Recommendation Report for Planning Permission for Works or Extension to a Dwelling

REF NO: LU/281/20/HH

LOCATION: 34 Jays Close
Littlehampton
BN17 6HQ

PROPOSAL: Ramp connecting to existing pathway to provide access to front entrance.

Client Name	Mrs A Pymm								
Address	34 Jays Close, Littlehampton								
Drawing Title	Existing & Proposed Front Access Plan								
Drawing Reference	HT/01/JaysClose34	Date	28/09/20						
Scale	1: 50	Paper	A3	Drawn By	HT	Revision		Direction

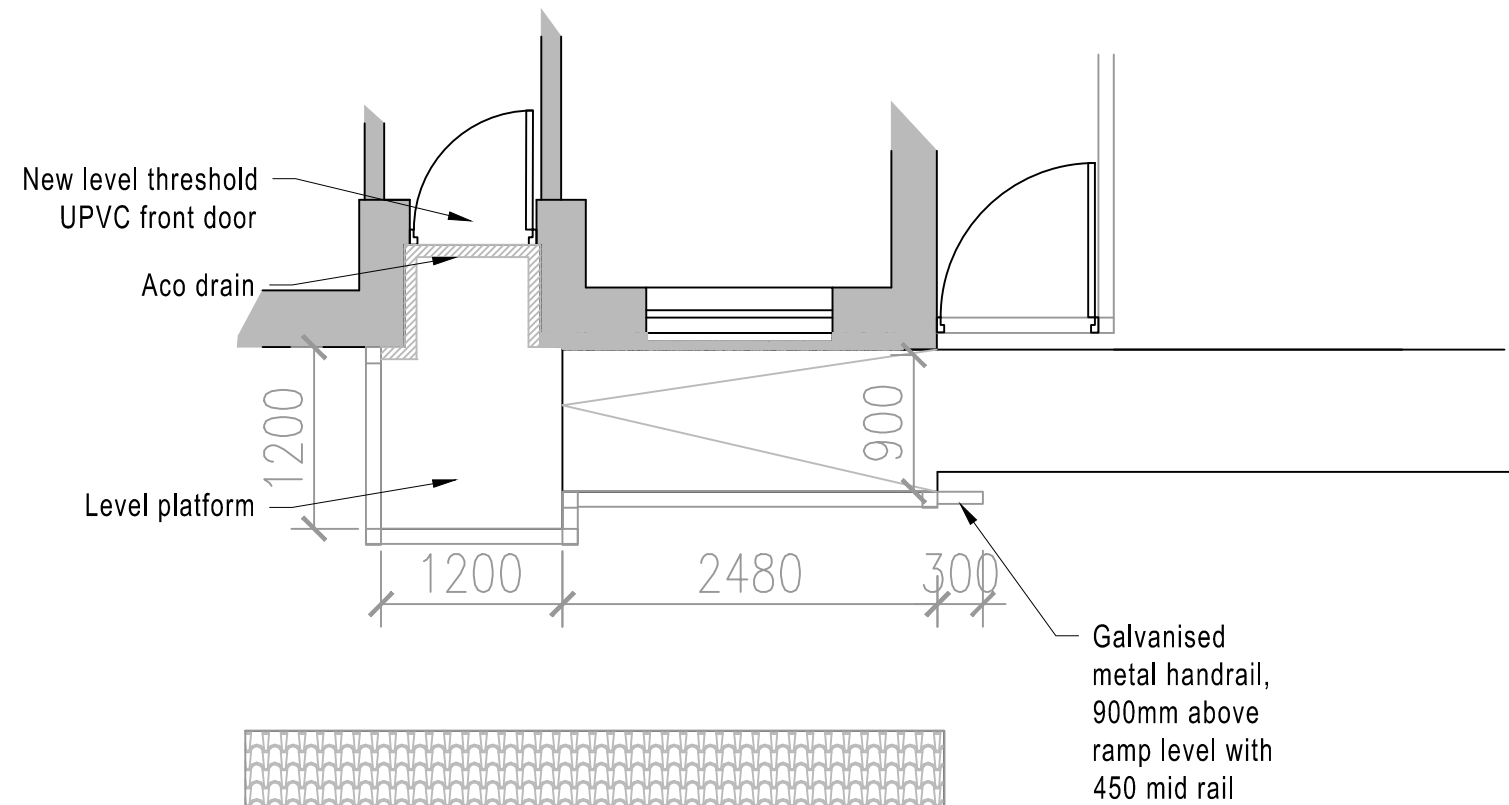
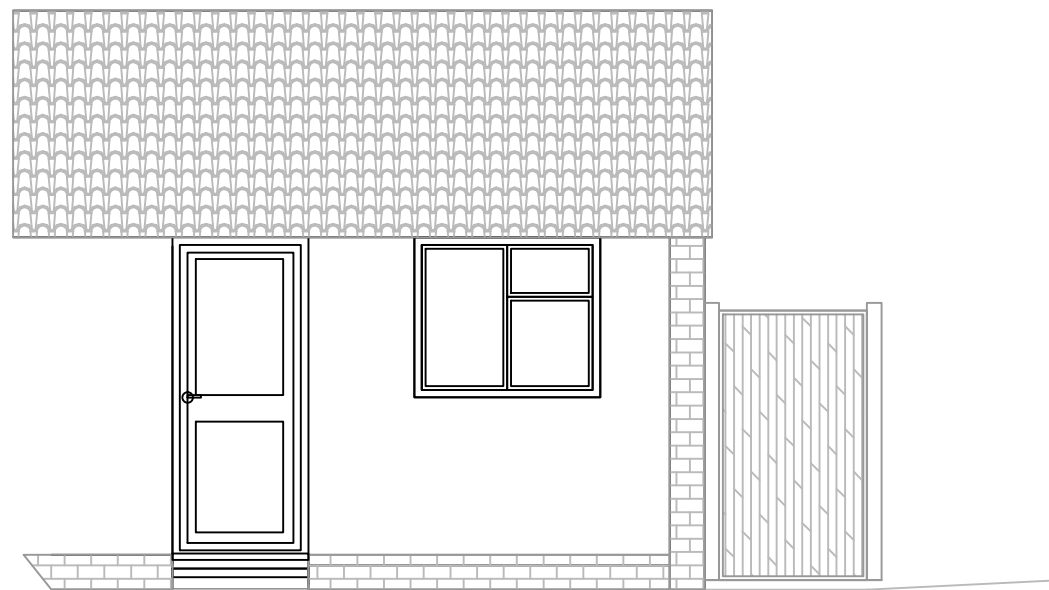
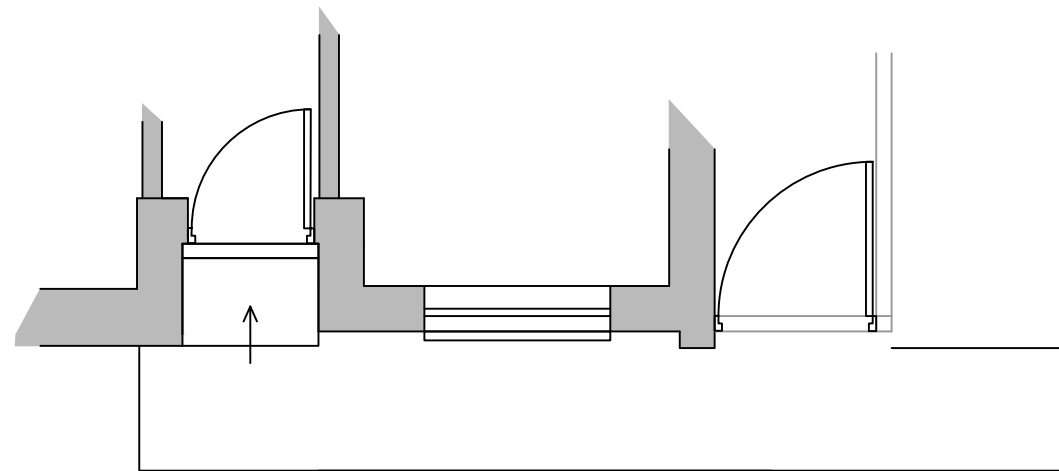
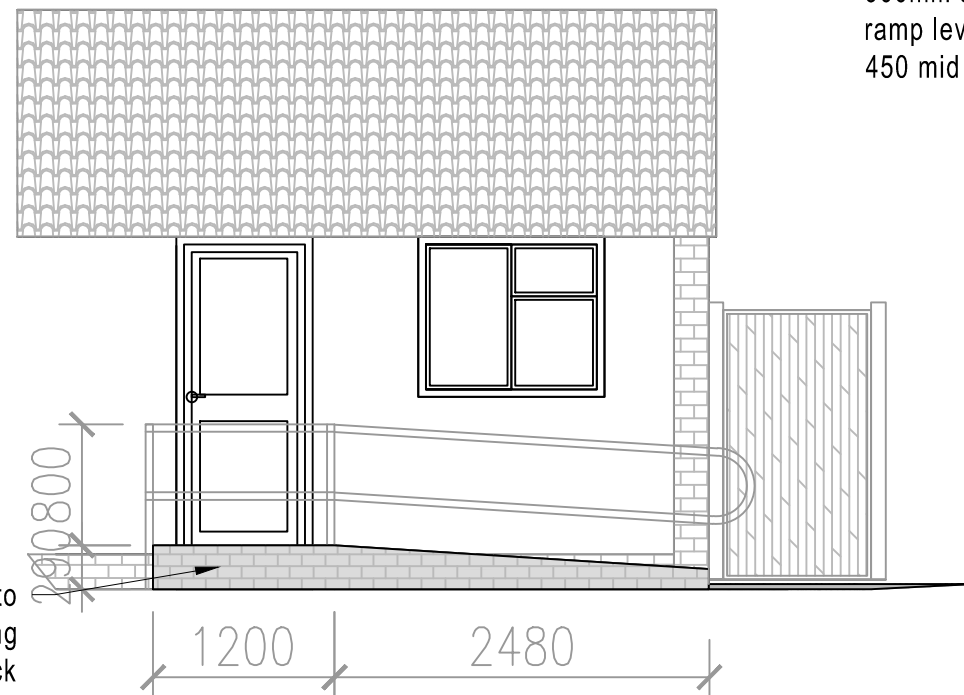
The ramp proposed has a length of 4.02m and a maximum height of 1.09m. The metal handrail will sit alongside the brick upstand which matches the existing brick property and is well integrated to the existing building. The development is considered to appear subservient to, and well integrated with dwelling. The ramp is not considered to have a detrimental impact on the application as this grants access and does not cause any harm to the character of the locality due to the location.

The ramp is not considered to have any impact on the neighbouring amenities as this will be used as an entry and exit point to the front entrance at the northern boundary of the property. Although the ramp will be seen at the street scene view at the front elevation it will cause minimal impact and will not result in any harmful overshadowing or overbearing impact upon the occupiers of neighbouring dwellings.
